**Maughanaclea Renewable Energy  
Development**  
Stage 1 Road Safety Audit

## Stage 1 Road Safety Audit

March 2026

Figure 15-24 Site access junction A on R585 - junction layout

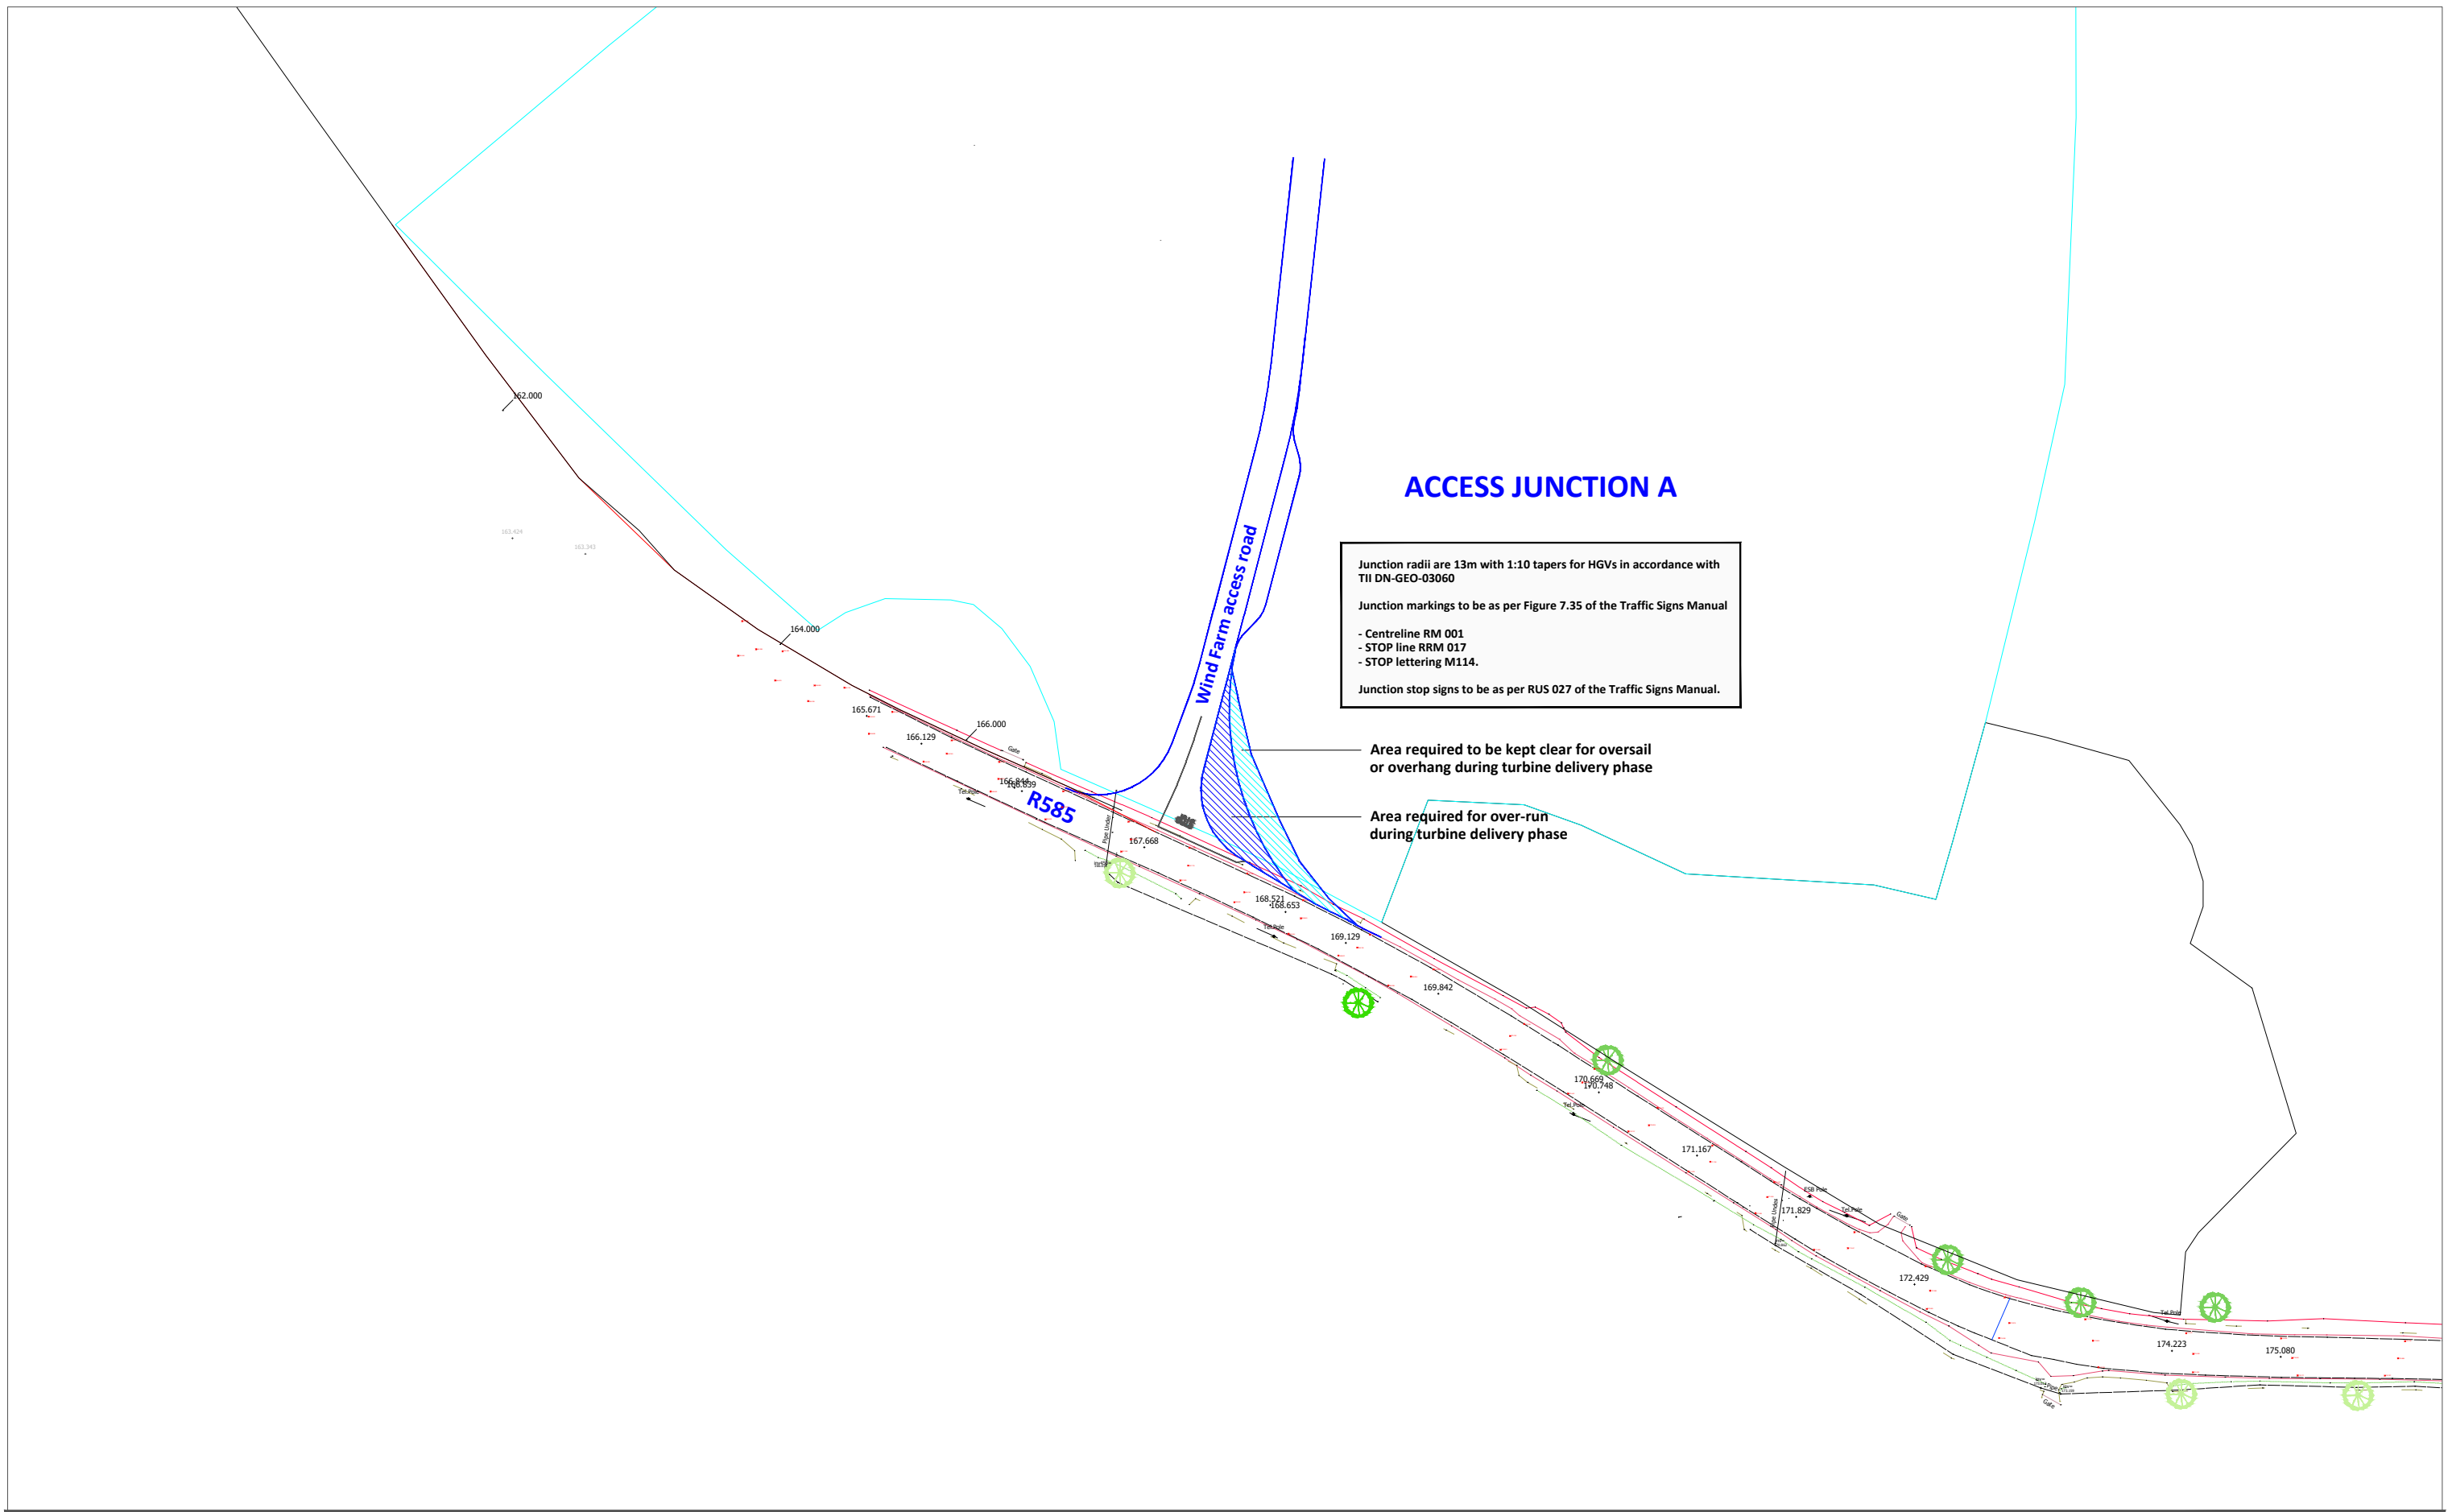
### 2.1 Problem: Passing Motorists Accessing Vehicle Overrun Area

**Location:** Junction A | Existing mainline carriageway to the east of the site

The over-run area might create confusion for passing motorists, who could access the overrun area by mistake, leading to sudden braking, loss of control or conflicts with construction traffic.

The Designer should ensure that a suitable barrier is put in place to prevent passing motorists from accessing the abnormal load overrun area when it is not in use.

2.1	Yes	Yes	A suitable barrier will be put in place at all times during the construction stage and opened only on the nights that the abnormal loads are delivered. On these occasions the deliveries will be accompanied by a Garda escort and the opened junction will be attended by site staff. On the completion of construction the over-run areas will be closed off permanently.	Yes

Figure 15-25 Site access junction A on R585 - visibility splays

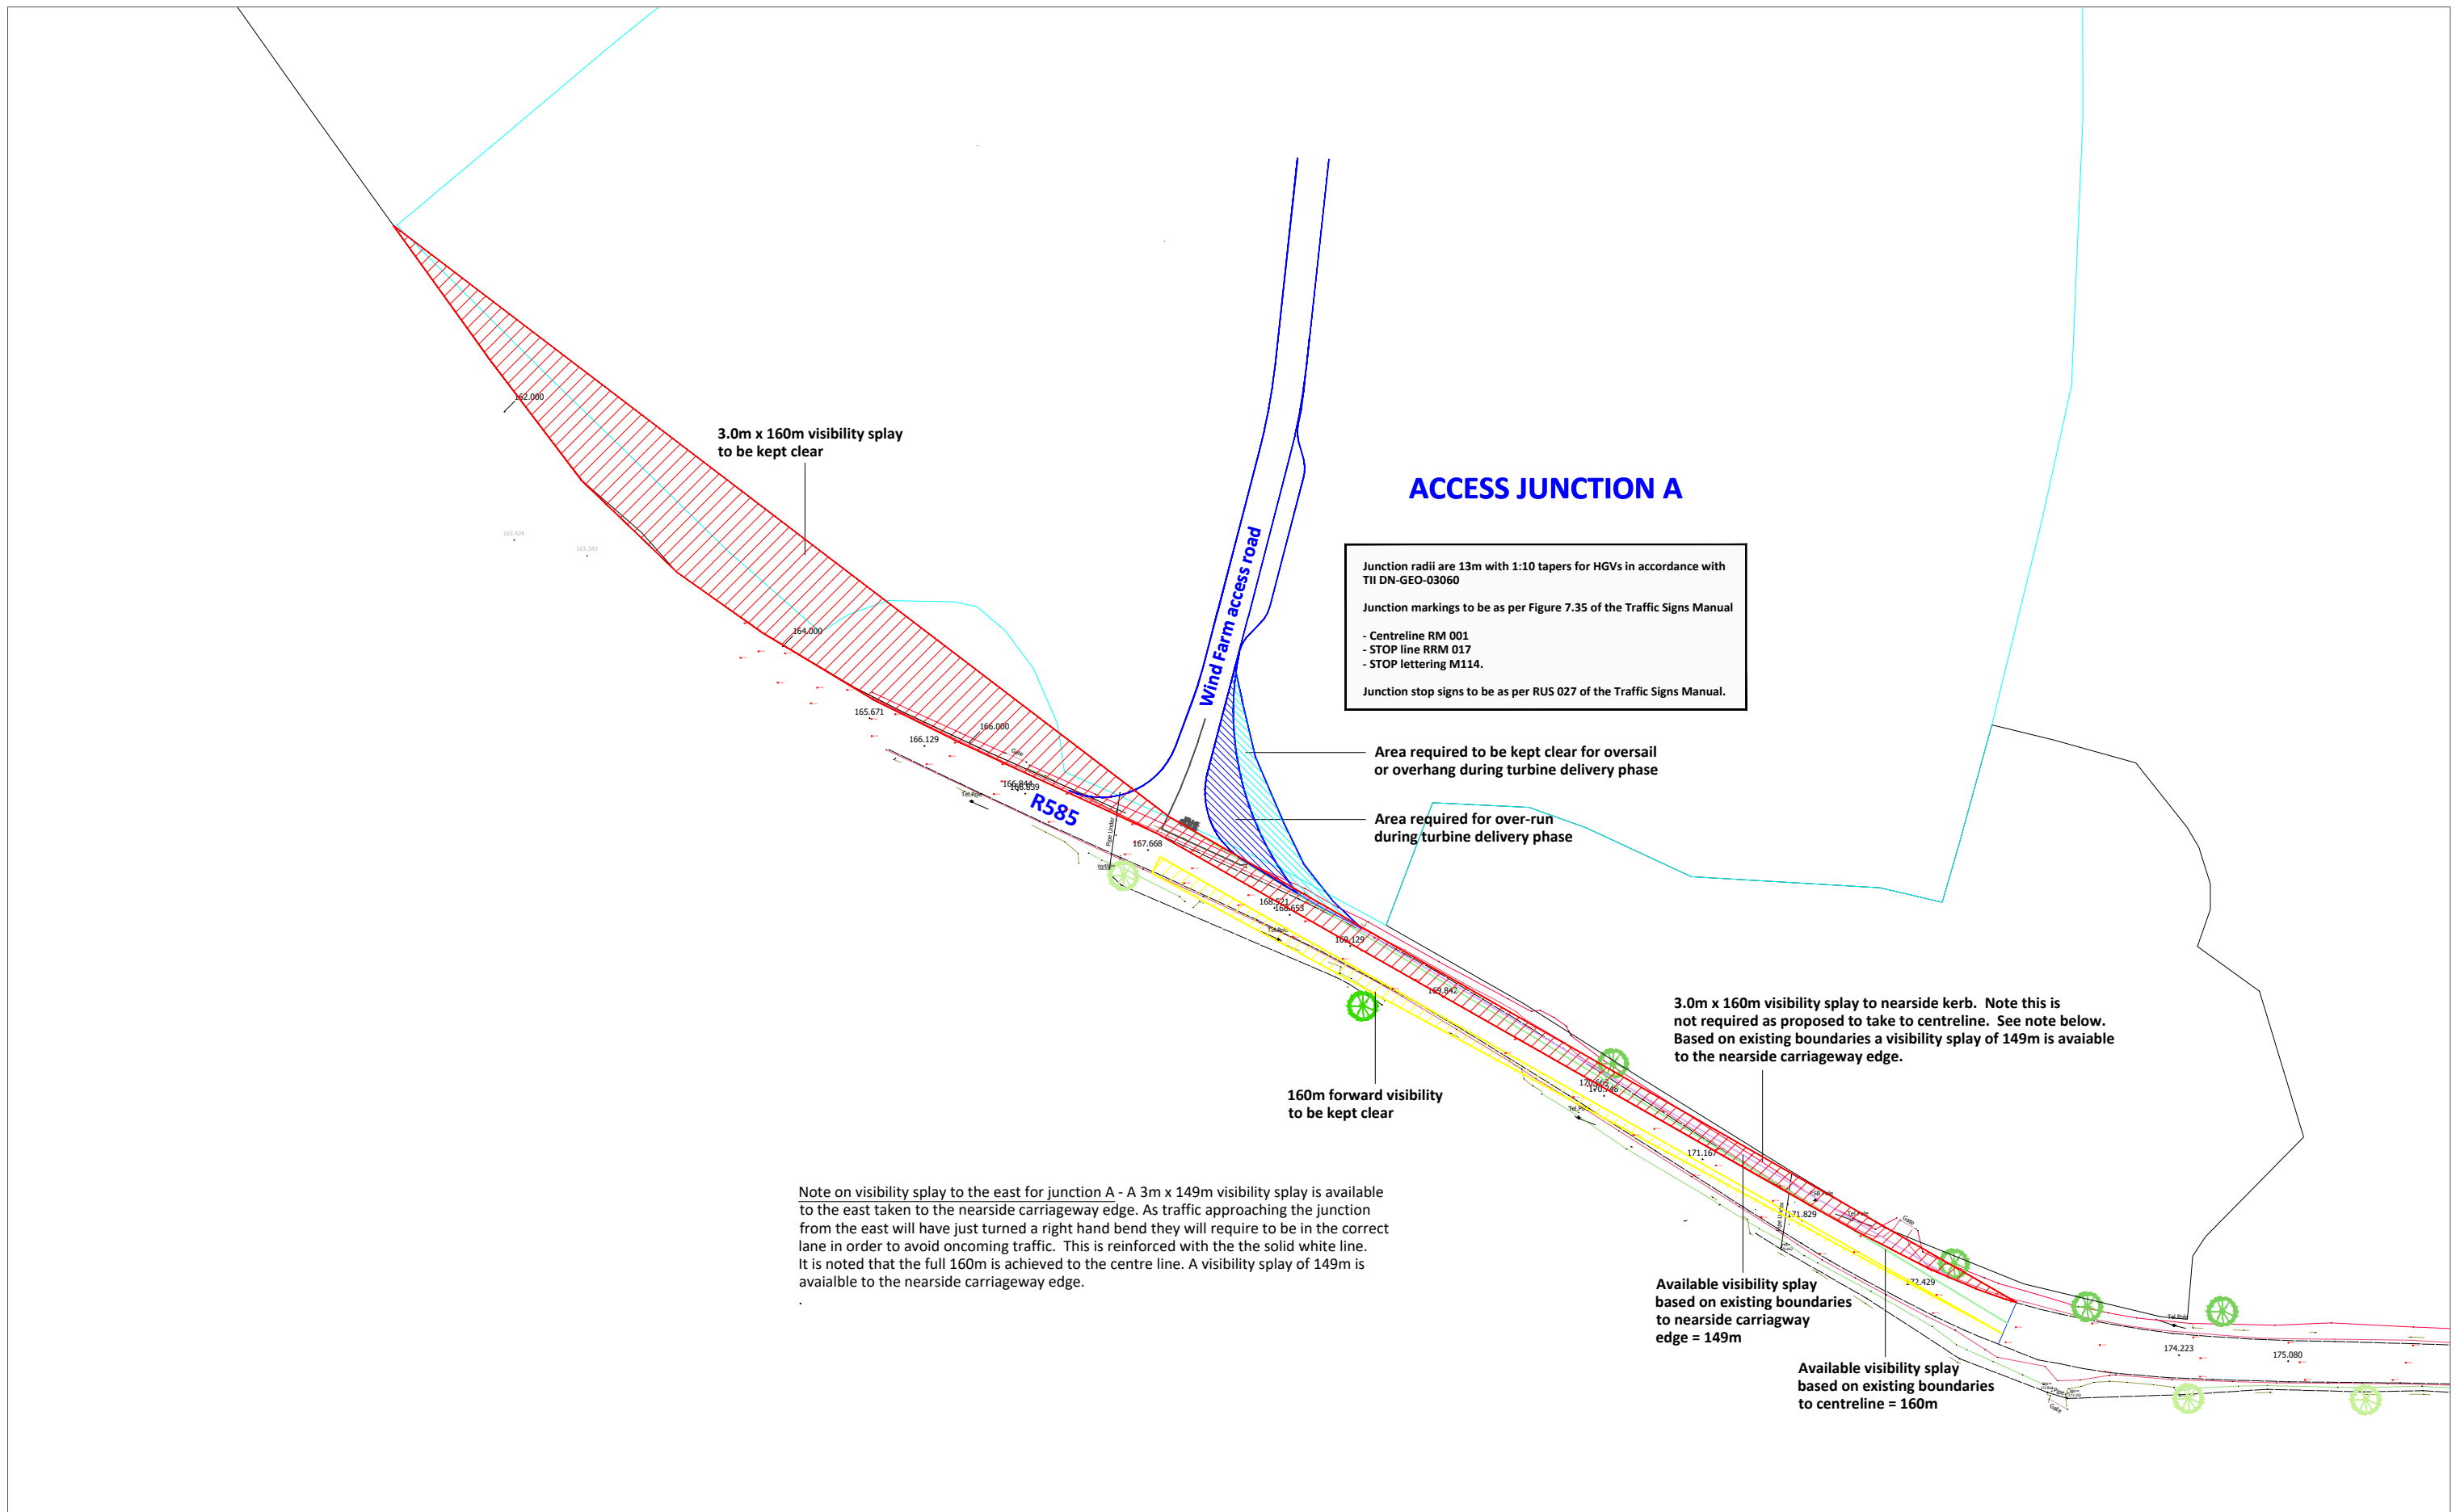
### 2.2 Problem: Visibility Splays Partially Obscured

**Location:** Junction A | Existing boundary treatments either side of access

Drivers attempting to leave the access will have their view blocked in both directions by the existing field boundary. This limited visibility could increase the risk of side-impact collisions at the access.

The field boundary should be modified to ensure that an appropriate level of visibility can be provided for drivers exiting the access

2.2	Yes	Yes	It is confirmed that the visibility splays described and shown in Figure 15-25 will be provided at all times.	Yes
2.3	Yes	Yes	The same response provided to 2.1 applies.	Yes
